Application for a non-material amendment following a grant of planning permission.

Number	8
Suffix	
Property name	
Address line 1	Church Road
Address line 2	Farnborough
Address line 3	
Town/city	Orpington
Postcode	BR6 7DB

<input type="text" value="CONVERSION OF EXISTING VACANT RETAIL UNITS TO FORM 2 X 1 BEDROOM FLATS"/>	
Reference number:	<input type="text" value="20/01771/FULL2"/>
Date of decision	<input type="text" value="27/05/2021"/>

CR/06B

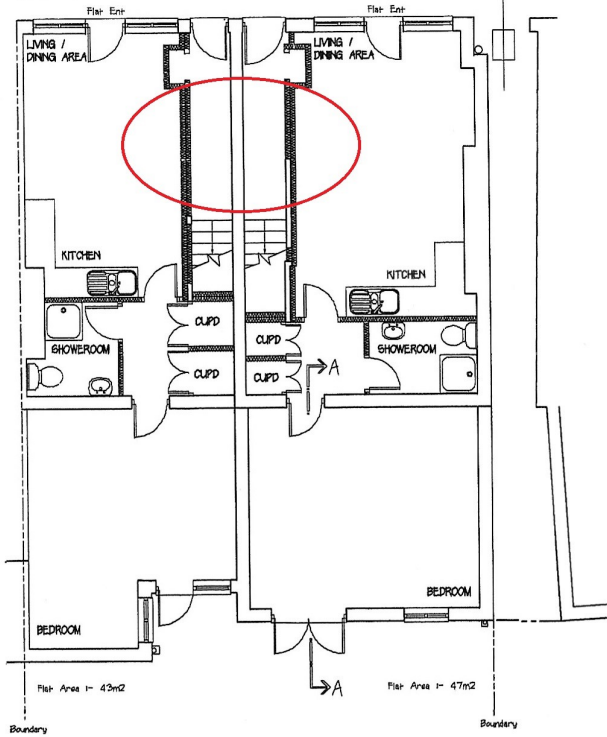
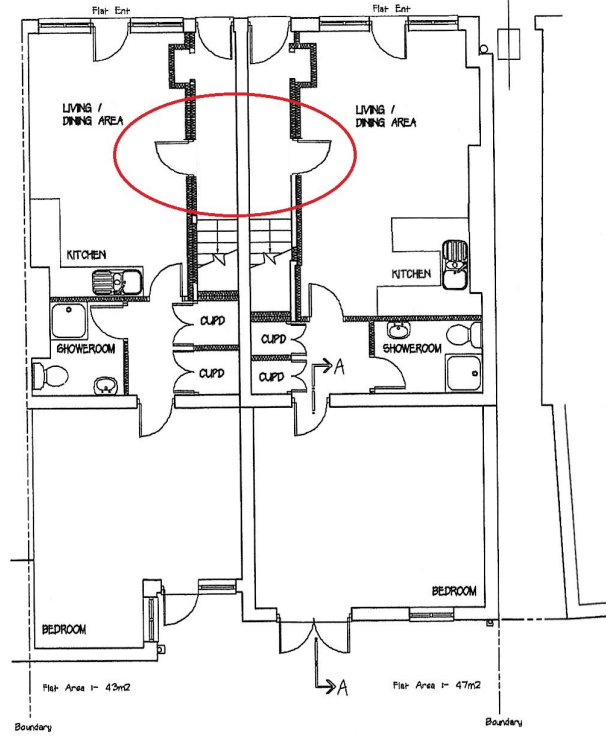
install internal door to both flats, this is to access to each flat from the existing Communal entrance.  
there will not be any changes made to the layout or the external appearance of the properties.

Old plan/drawing numbers

CR/06

New plan/drawing numbers

The changes are proposed to give the occupant the option of making better use of the lounge are, this will be possible by not using the original shop doors
